FERTILIZER - CHEMICAL BUILDING

FLYING HORSE NORTH
Colorado Springs, CO

Floor Plans.pdf Markup Summary

SD1.0
Site Development
Plan
Scale
1" = 20'-0"

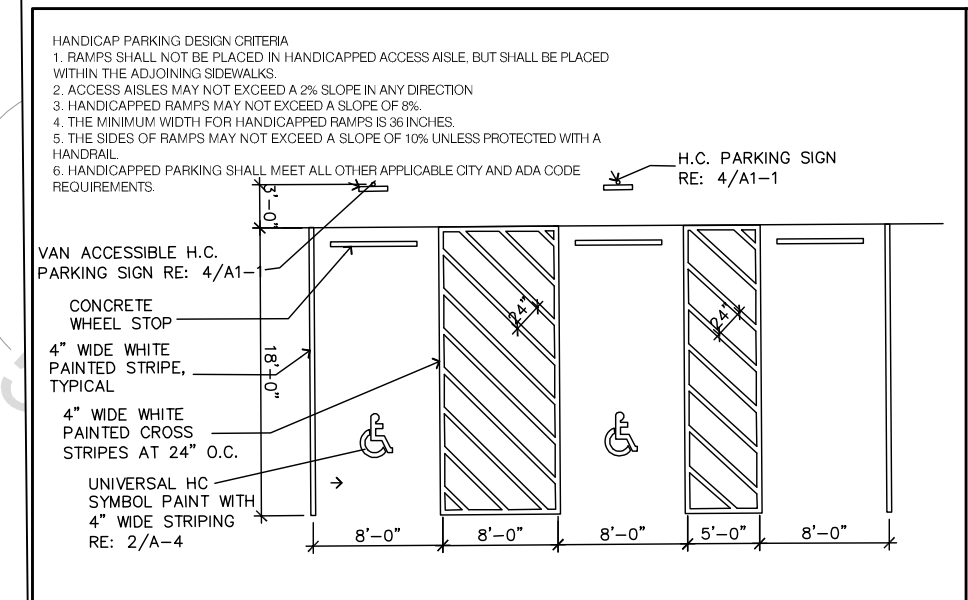
Parking - Professional Offices - 1space per 200 sq ft

Parking -
Warehouse - 1 space per 1000 sq ft

No parking - Not manned
